Application for a Non-Material Amendment Following a Grant of Planning Permission

Mount Park Road

Demolition of existing garage and erection of single storey outbuilding in garden for use as an office and store room, and erection of a single storey rear extension.

34218/APP/2021/3383

SCALE: 1:50 @ A1  
Drawn by: ML  
Drawing no: 201 rev C  
Date: 26.08.2021

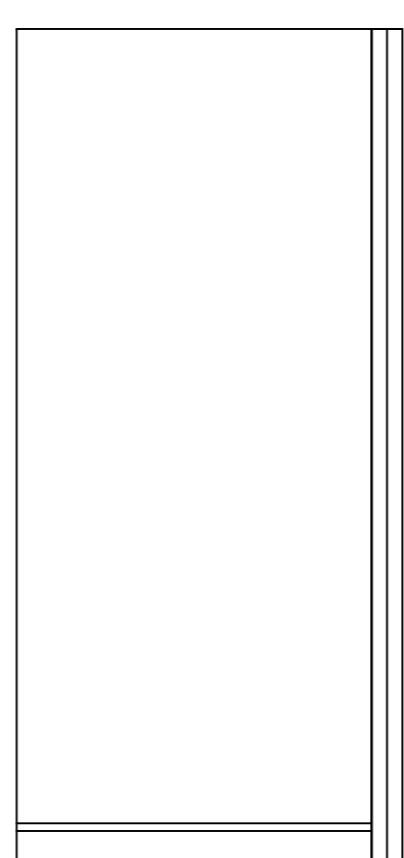
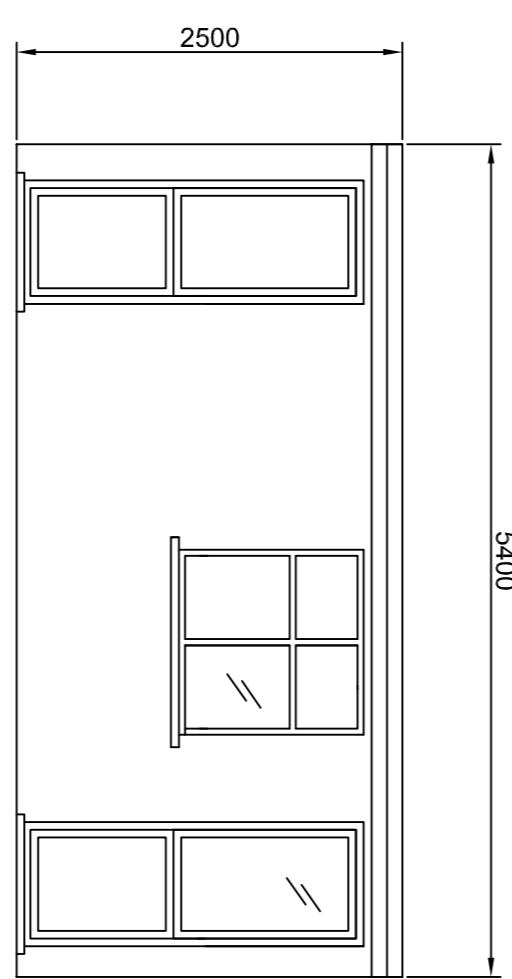
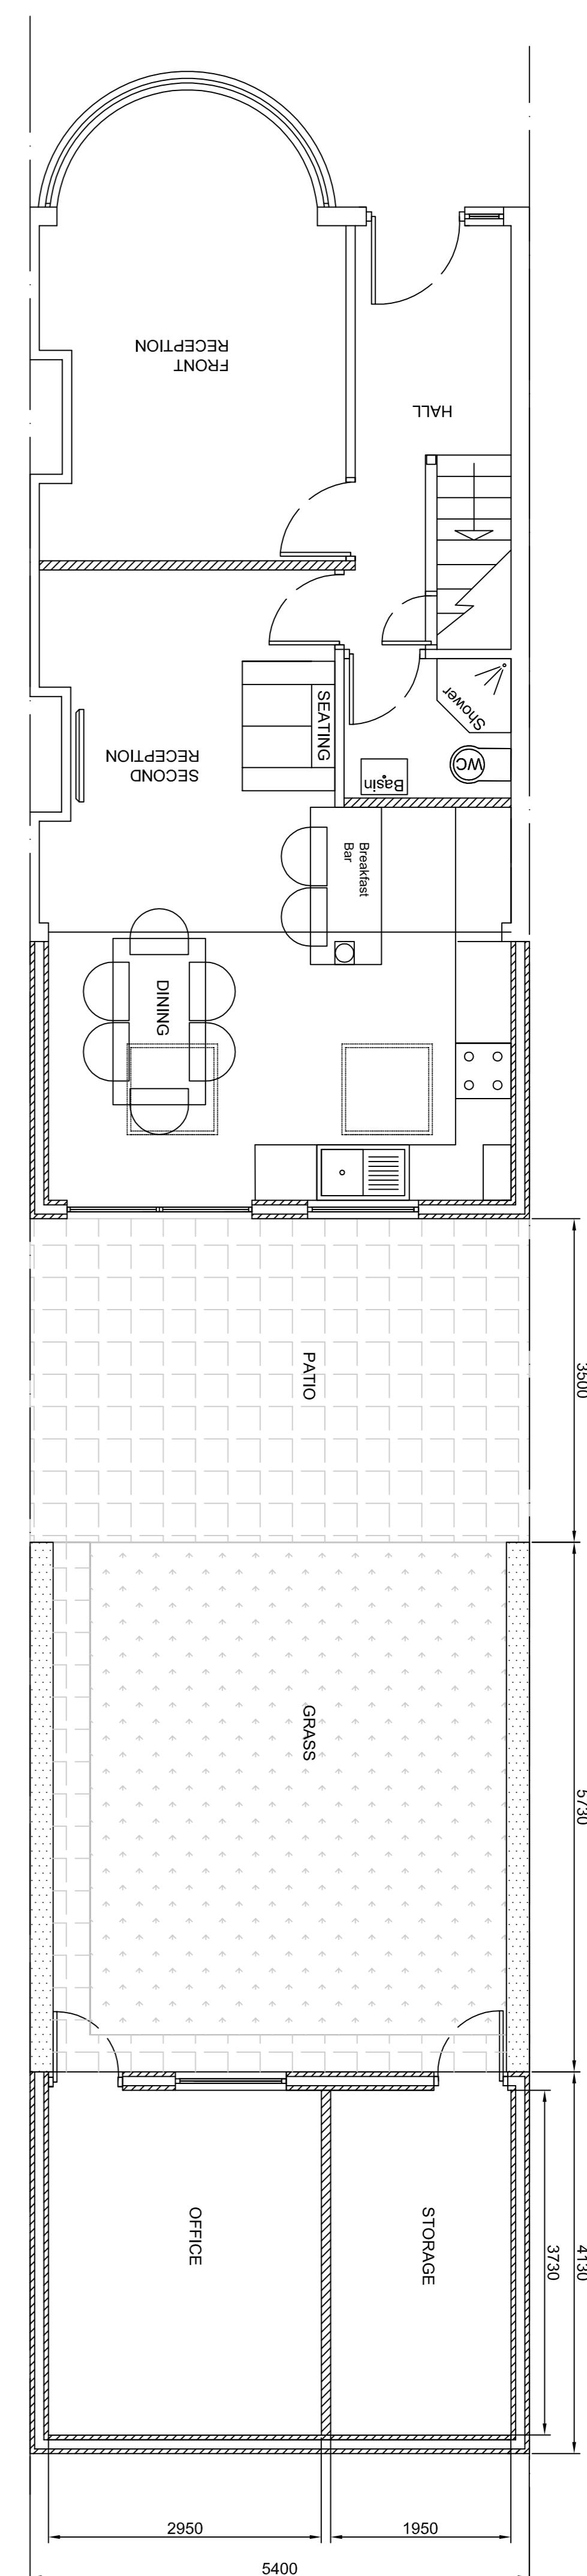
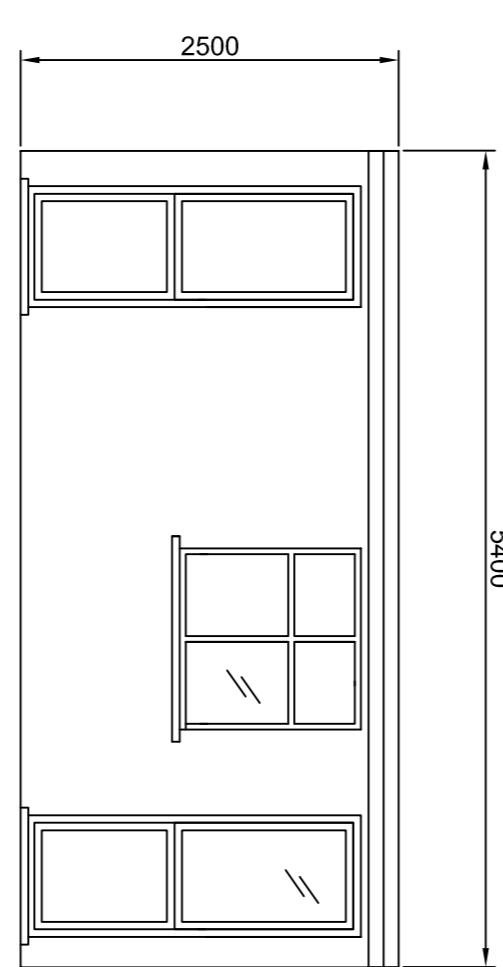
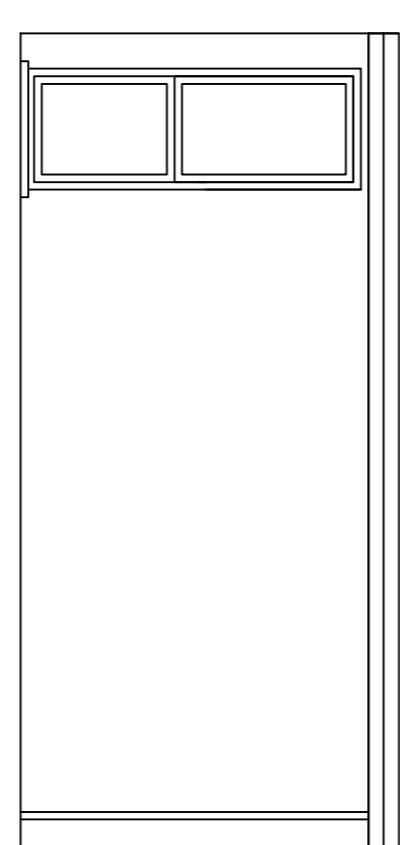
Single door to be added to store room section of outbuilding at rear.

Adding a single door to the store room section of the outbuilding will allow access for gardening waste disposal, and use of the family bicycles.
